From: Ross and Dianne Franklin <randdfranklin@yahoo.com.au>
To: <plan_comment@planning.nsw.gov.au>
Date: 29/11/2012 7:32 AM
Subject: Fwd: Attention Director Infrastructure Projects

Re Application number (SSI-5414)
 North West Railway Environmental
 Impact Statement EIS2

Figure 6.12 Cherrybrook Station - Indicative vehicle and pedestrian movements

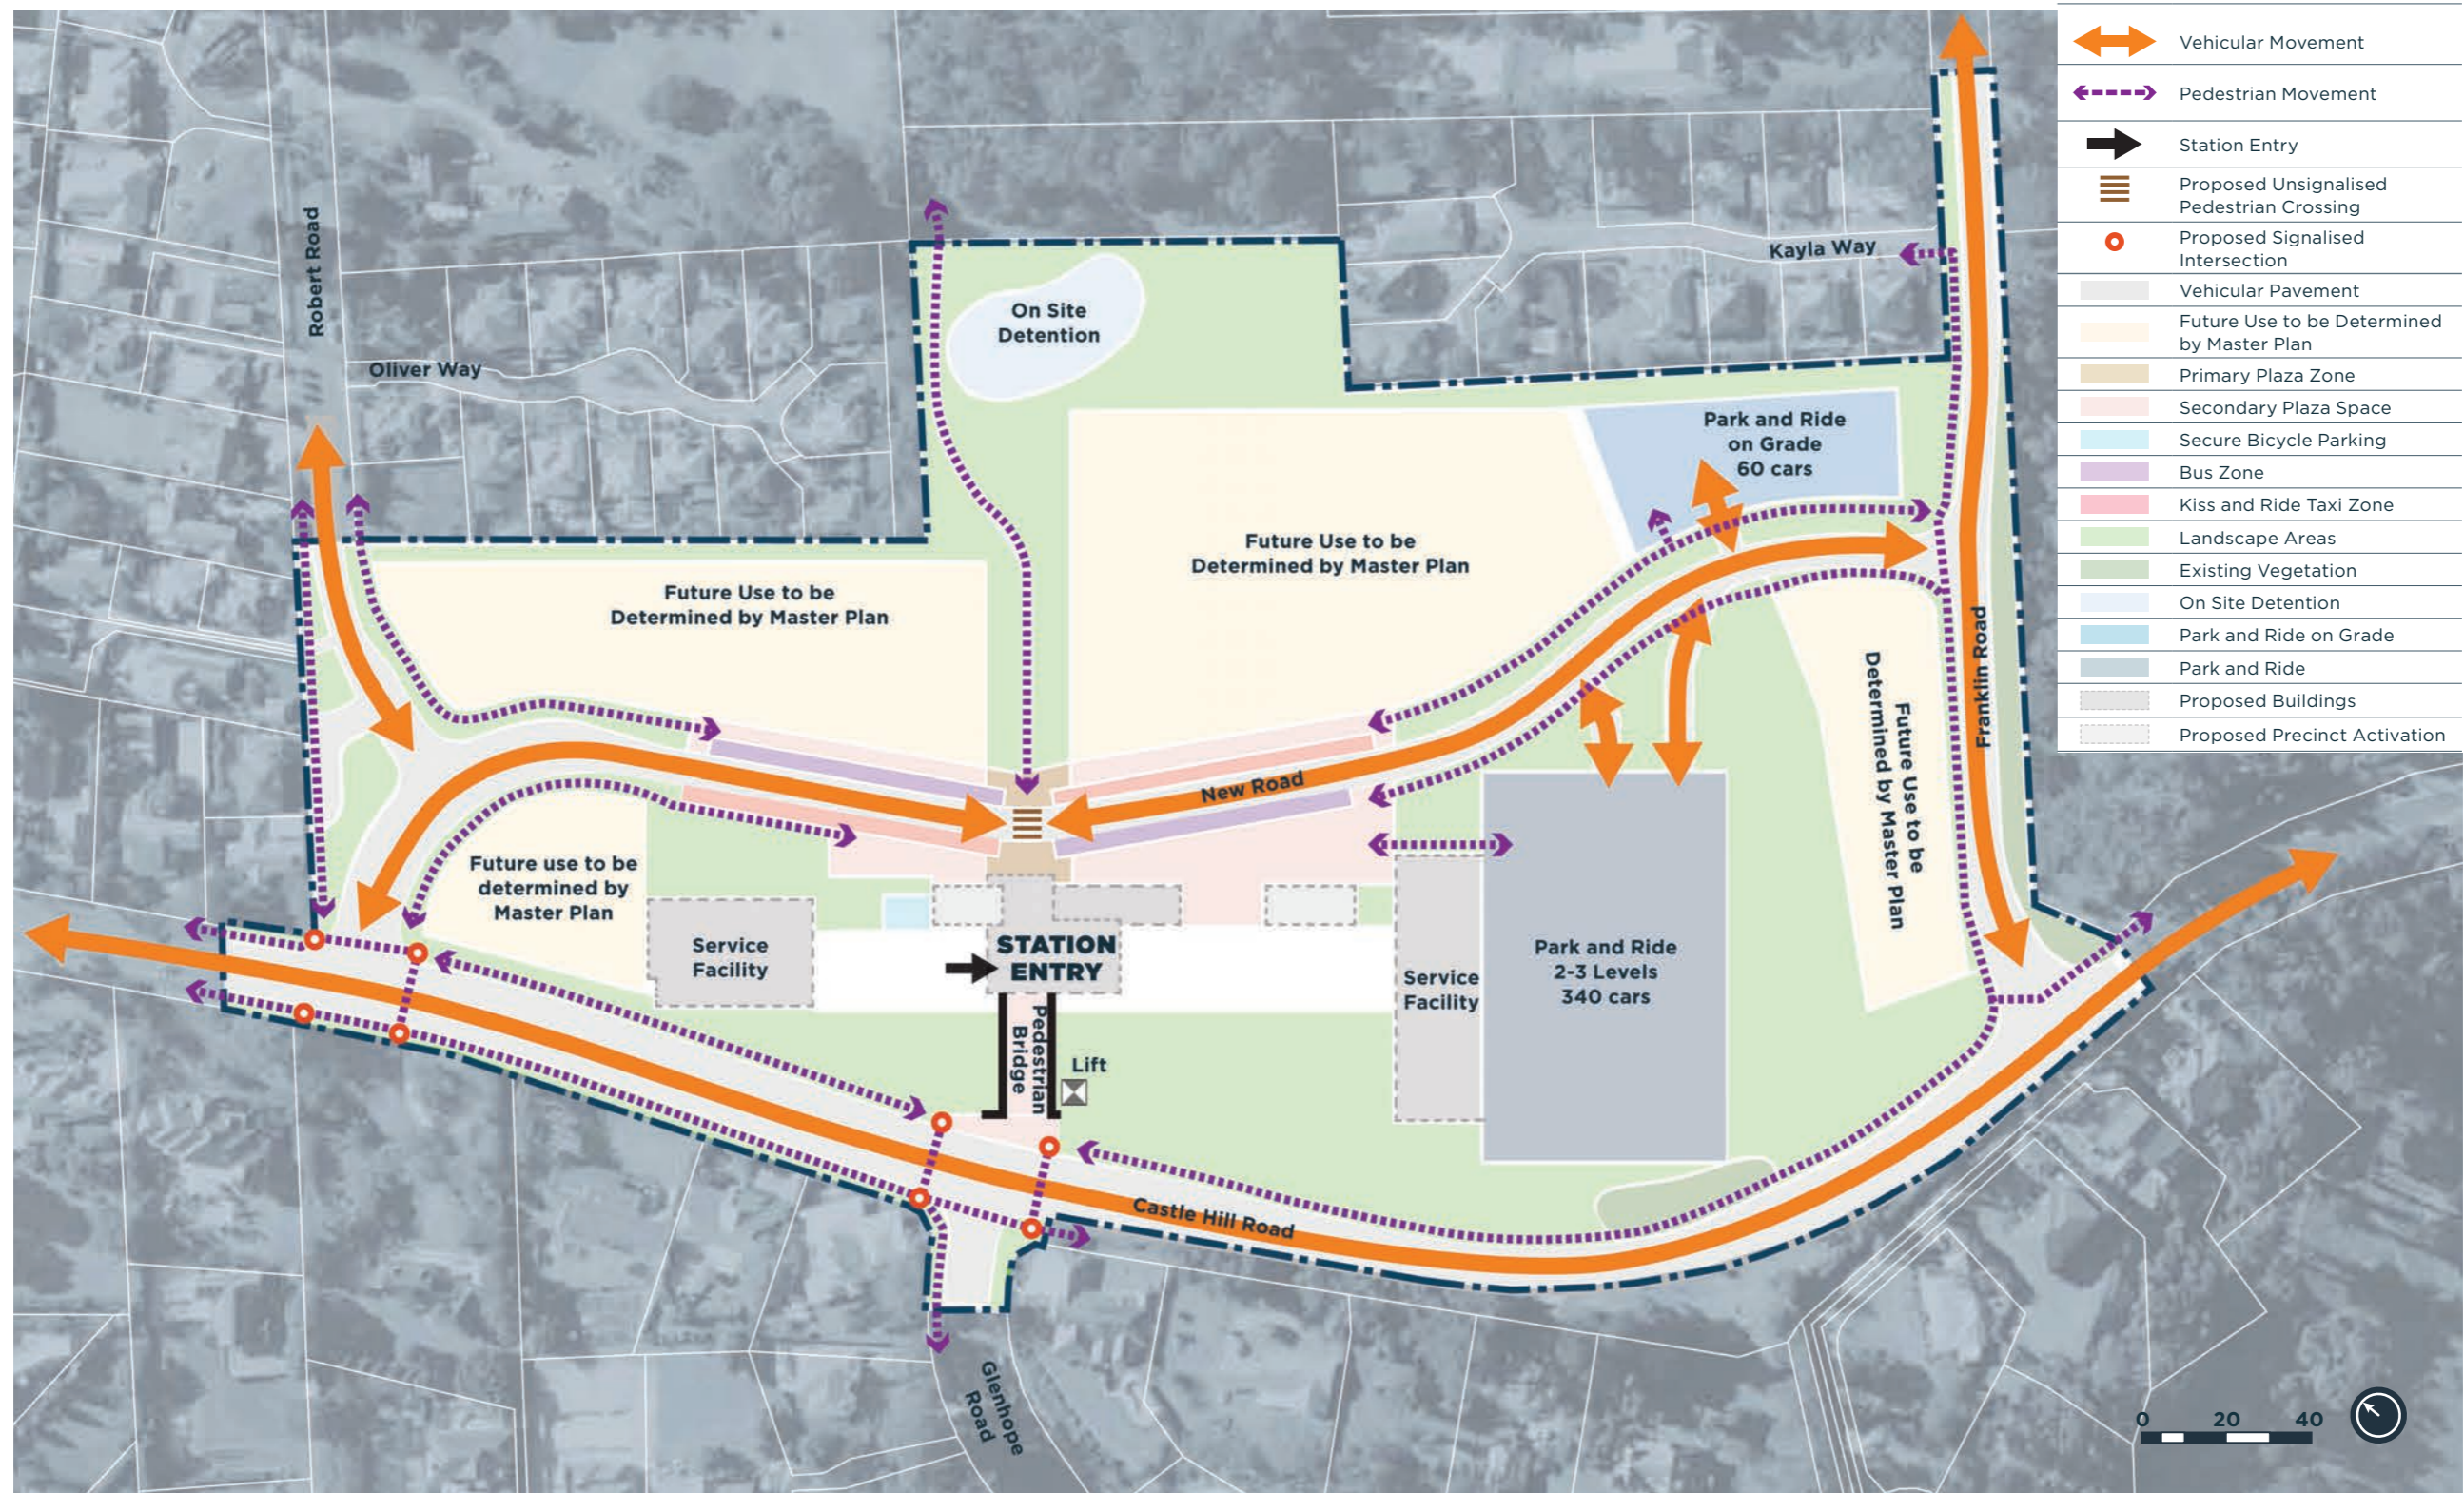
Whilst we support the overall concept of the NWRL we object to the use of Robert Rd as a feeder road to the proposed Cherrybrook Station for buses and general traffic as set out in the NWRL EIS2
 We live in a private community off Robert Rd.

- 1 Robert Rd was designed and built as a low level road for local residents.
- 2 The road is only 7 metres wide and is too narrow to accommodate the proposed type and level of traffic.

- 4 The plan to limit kerbside parking in Robert Rd due to the narrow road width would have an enormous impact on local residents when family or friends visit or when trade persons are required.
 County Drive which is a major arterial road allows resident kerbside parking.

- 5 The entry to Robert Rd from John Rd is hazardous with poor visibility due to the steep hill approach.
- 6 There is park with a childrens play ground on Robert Rd. This park is very well used by local children and residents. Increased traffic would increase the danger around the park.

- 1 Traffic approaching the Railway Station along County Drive should continue to the intersection with Castle Hill Rd.
- 2 County Drive approaching Castle Hill Rd becomes a 4 lane road.
- 3 Of the 4 lanes on County Drive exiting County Drive, 2 lanes are designated right turn into Castle Hill Rd, 1 lane designated straight ahead into Highs Rd and 1 lane left into Castle Hill Rd. This left turn lane is the least used with currently about 5% of the traffic turning left towards the proposed station.
- 5 It would seem logical to follow this route as the traffic lights give a good break for traffic turning left and approaching the proposed station.
